SUBJECT: Engineering Review Comment
Mountain View Electric Association Inc. (MVEA)

Project Name: Overlook at Homestead Filing 1 – Final Plat

Project Number: SF2425

Description: Proposed development of 36 residential lots located east of Elbert Rd. and north of Sweet Rd. in Township 11S, Range 64W, Sections 22 and 27.

FINAL PLAT

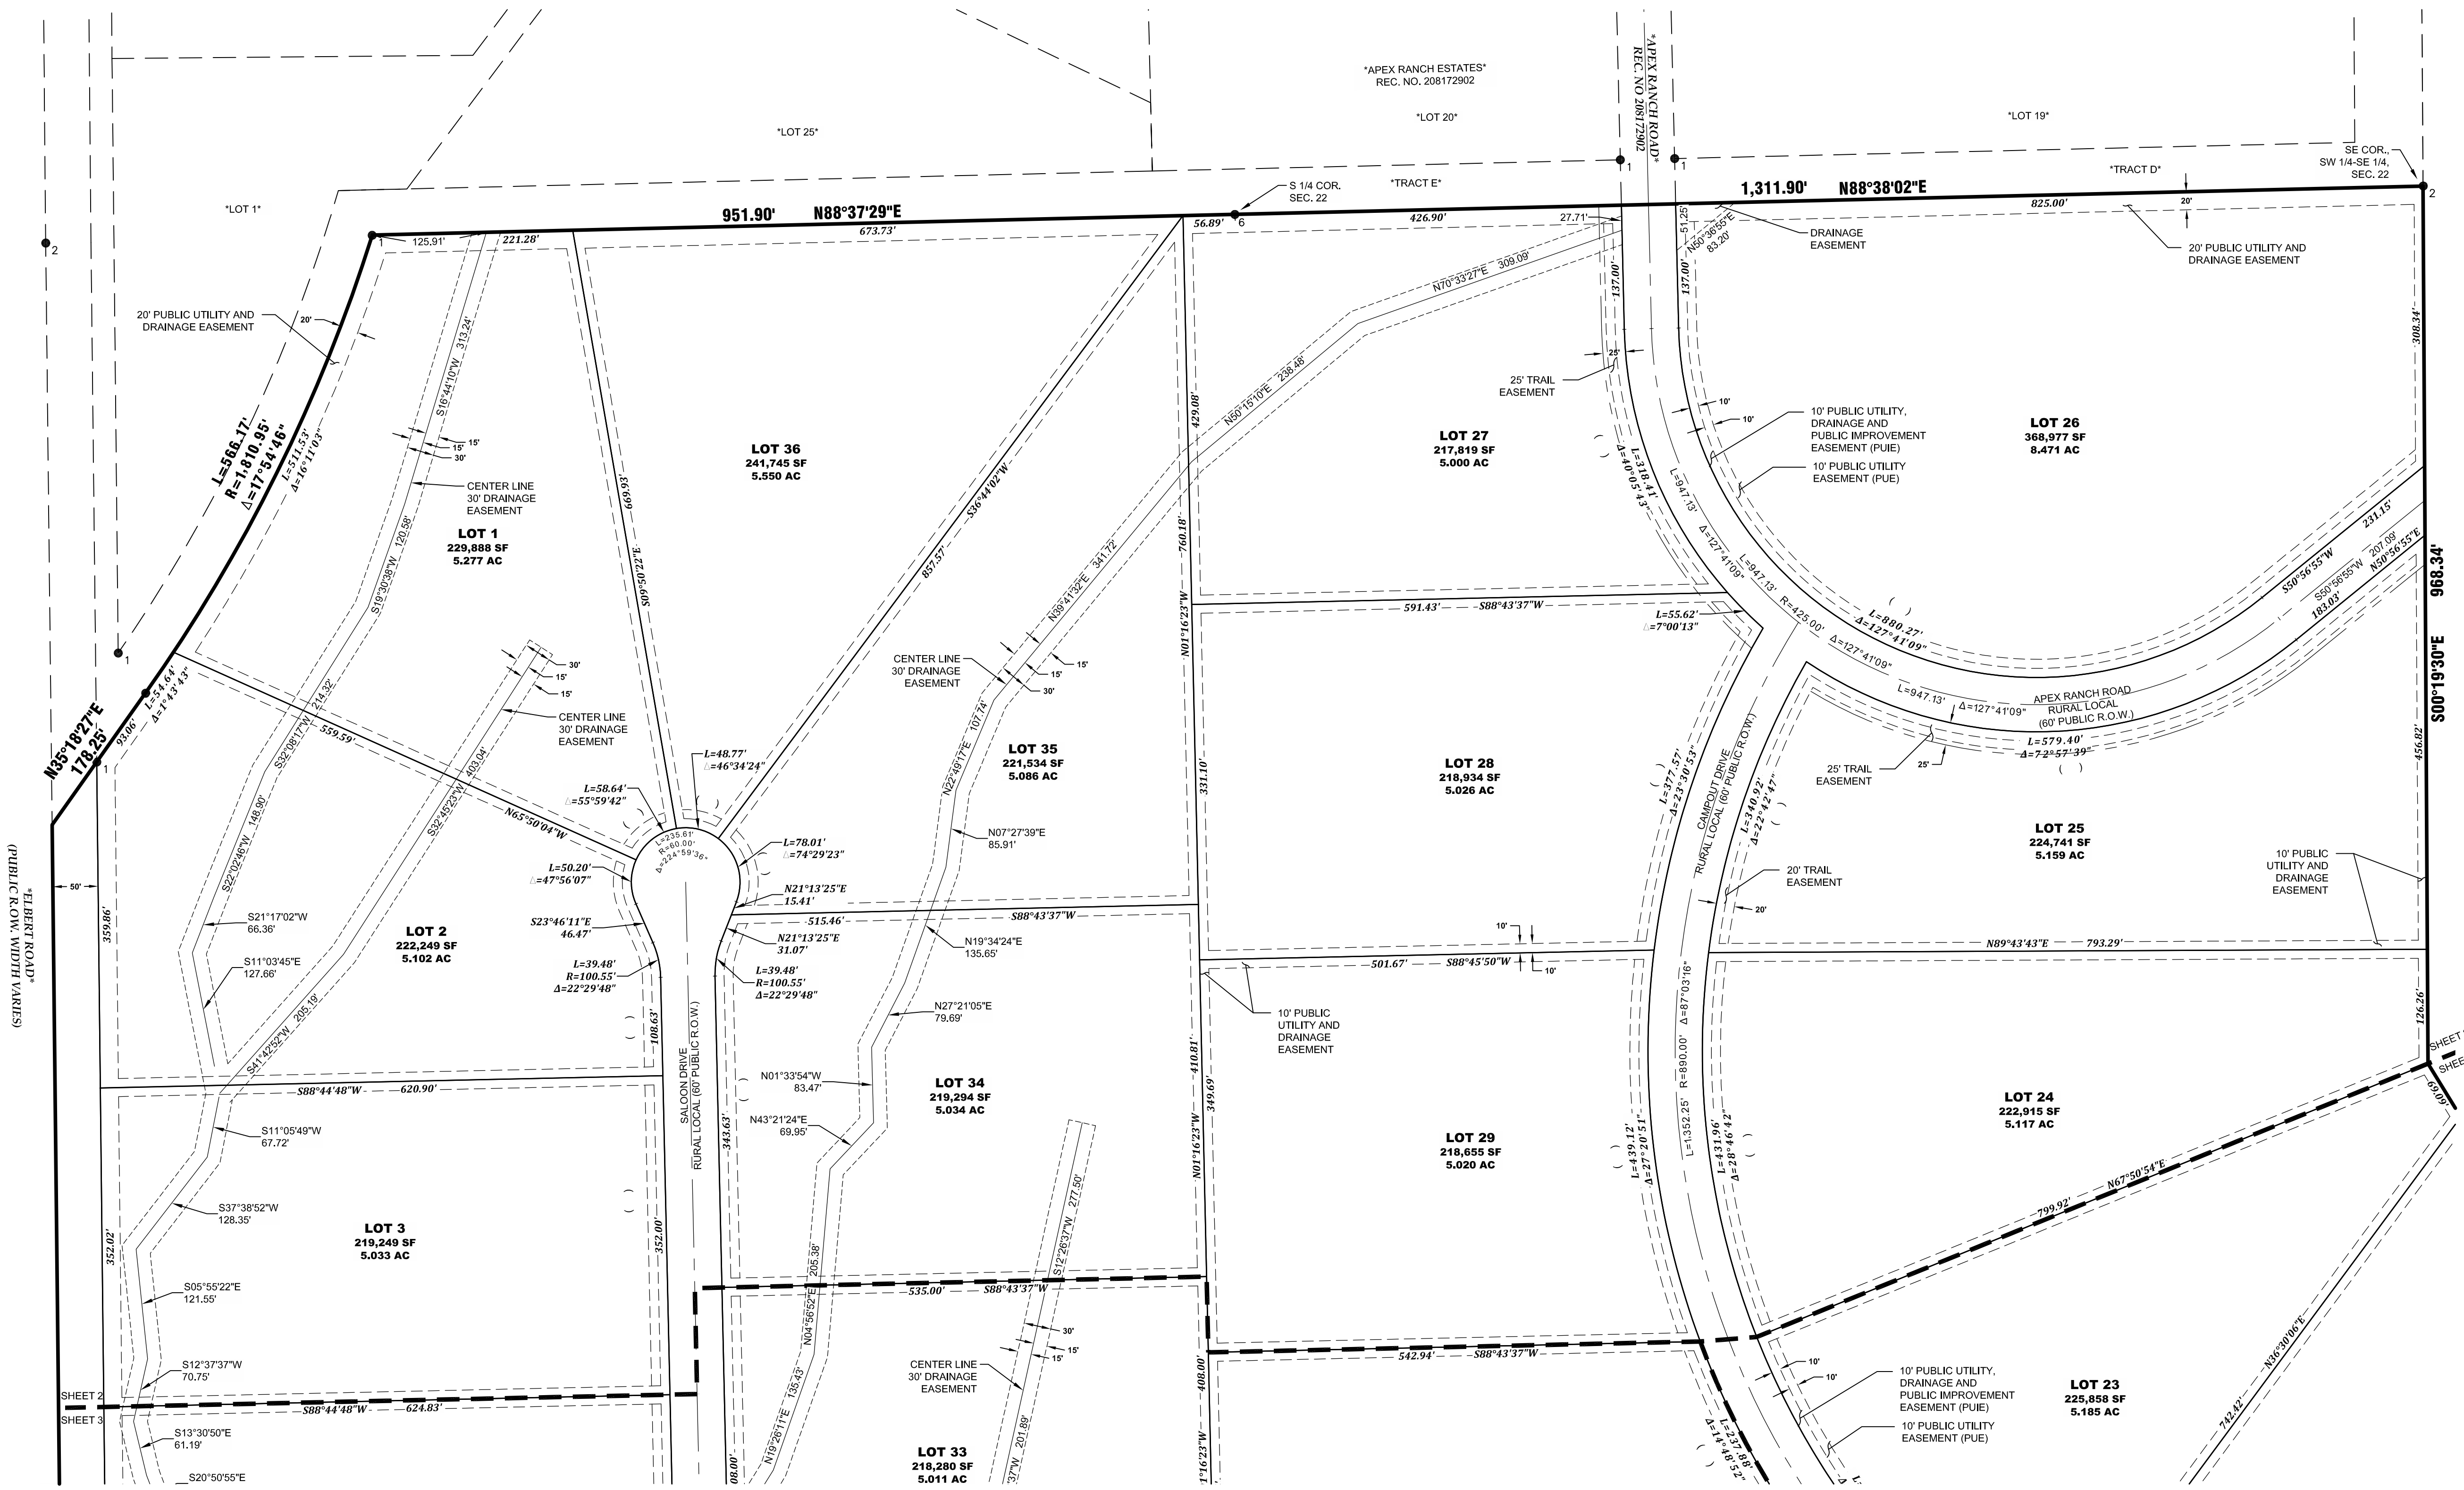
MVEA requests a ten (10) foot front, side, and rear lot utility easement and all tracts, along with a twenty (20) foot exterior utility easement on the plat. MVEA also requests the platting of MVEA's existing facilities with easements on the plat. Additional easements may be required.

MVEA requests an additional 10' easement adjacent to the preservation easement and include the use of public utilities in the tract table.
